Name of Submitter	SP 73154 - Woolloomooloo Finger Wharf Commercial 6 Cowper Wharf Road, Woolloomooloo NSW 2011 “WFW” c/- McCormacks Strata Management Suite 5.01, Level 5, 151 Castlereagh St Sydney NSW 2000 samantha@mccormacks.com.au
Application Name	Art Gallery of NSW Expansion Project – Sydney Modern
Application Number	SSD 6471
Applicant	Art Gallery of NSW Trust
Council Area	City of Sydney
Approval Authority	Minister for Planning
Donation declaration	No reportable political donations in the last 2 years

Objection Statement

Reasons for Objection

Fig 8.0A – Proposed location of intake and discharge points

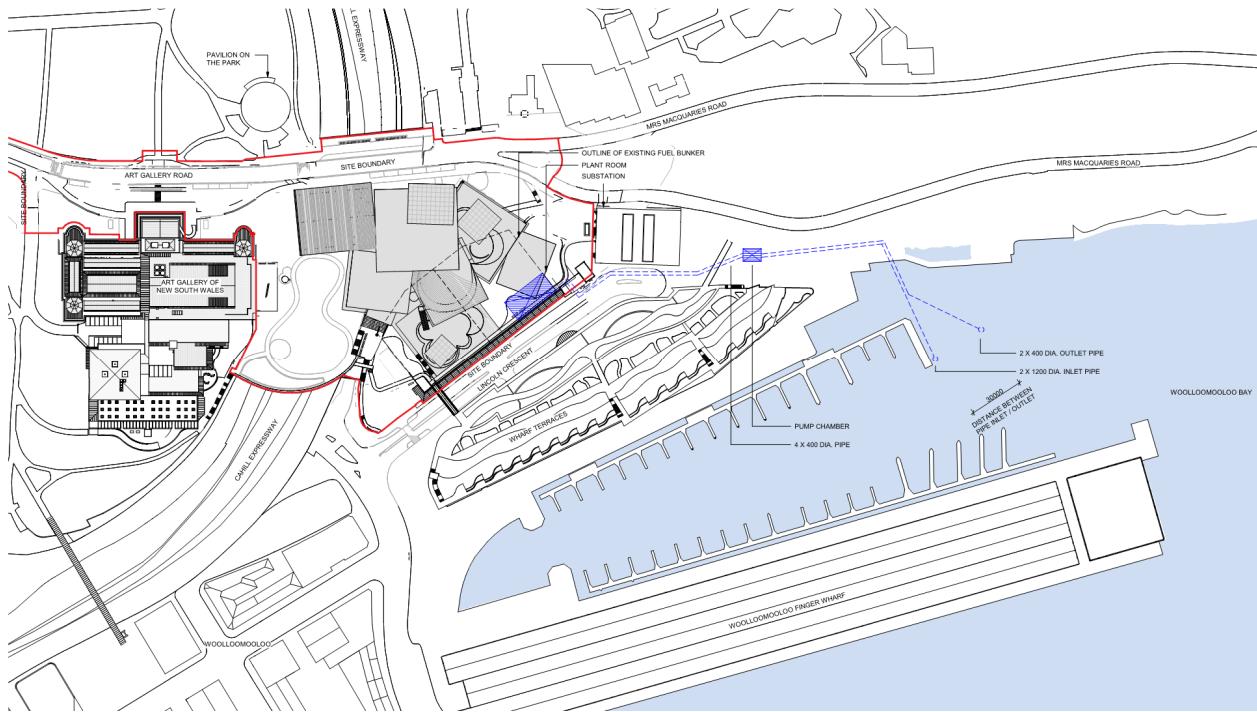
Comment - there appears to be no detail on how the SMP will impact on WFW. The report does not make it clear what the impact is of the temperature differential (2 degrees) on marine structures, boats and marine life.

Request – provide details on the impact of the temperature differential (2 degrees) on marine structures, boats, marine life and WFW substructure (the piles that support the wharf and marina structure). Agreement that WFW's engineering consultant review the application
